From: Nolan, Chris <Chris.Nolan@lancashire.gov.uk>
Sent: 07 February 2018 09:07
To: Adam Birkett; planning
Cc: LHS Customer Service
Subject: D3.2018.0044 - Out Lane Head Farm Collins Lane Chipping

Planning Application No: 3/2018/0044
Grid Ref: 360381 443687
Proposal: Replacement dwelling and associated works.
Location: Out Lane Head Farm Collins Lane Chipping PR3 2NQ

Ground Floor & Partial Site Plan

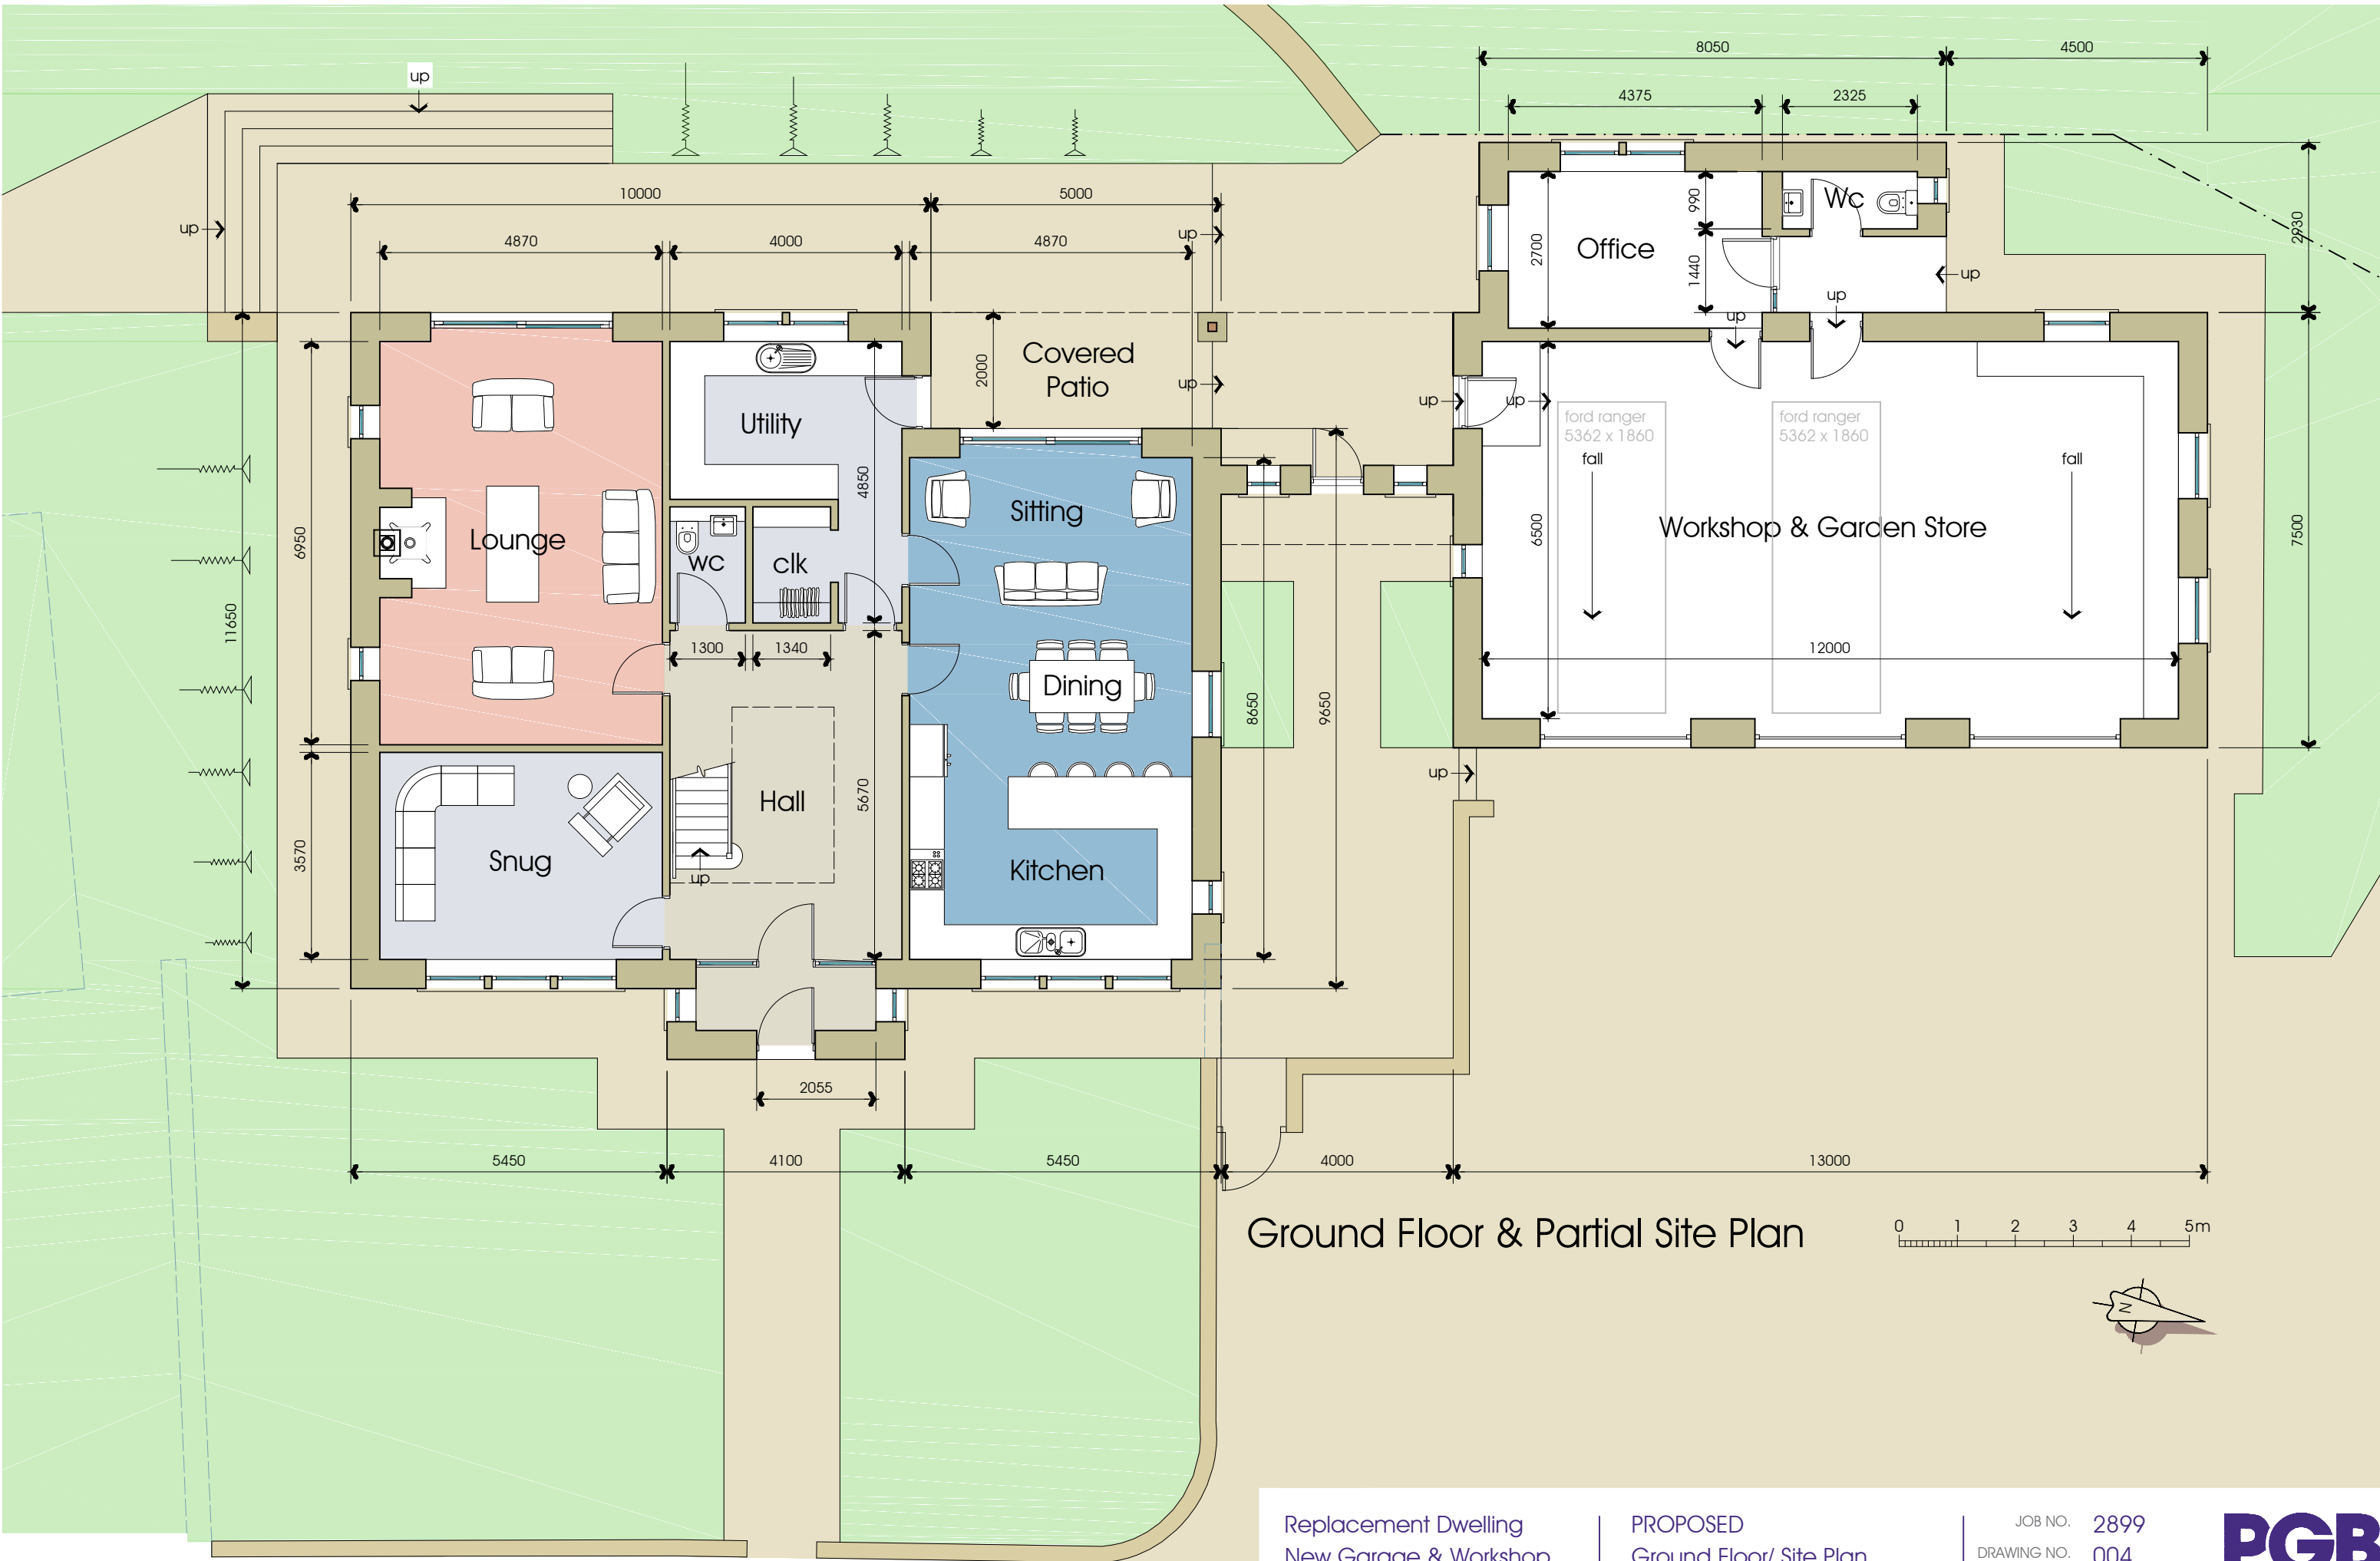
1. Before the completion of the new dwelling, that part of the parking area extending from the highway boundary for a minimum distance of 5m into the site shall be appropriately paved in tarmac, concrete, block pavements, or other approved materials and that this will be maintained for the period that the parking area is in use. Reason: To prevent loose surface material from being carried on to the public highway thus causing a potential source of danger to other road users.

2. Before the new dwelling hereby permitted is occupied, the existing vegetation on the highway frontage of the site to Collins Lane shall be reduced to and be permanently maintained henceforth at a height not greater than 1m above the crown level of the carriageway of Collins Lane. Reason: To ensure adequate visibility for the drivers of vehicles entering and leaving the site.
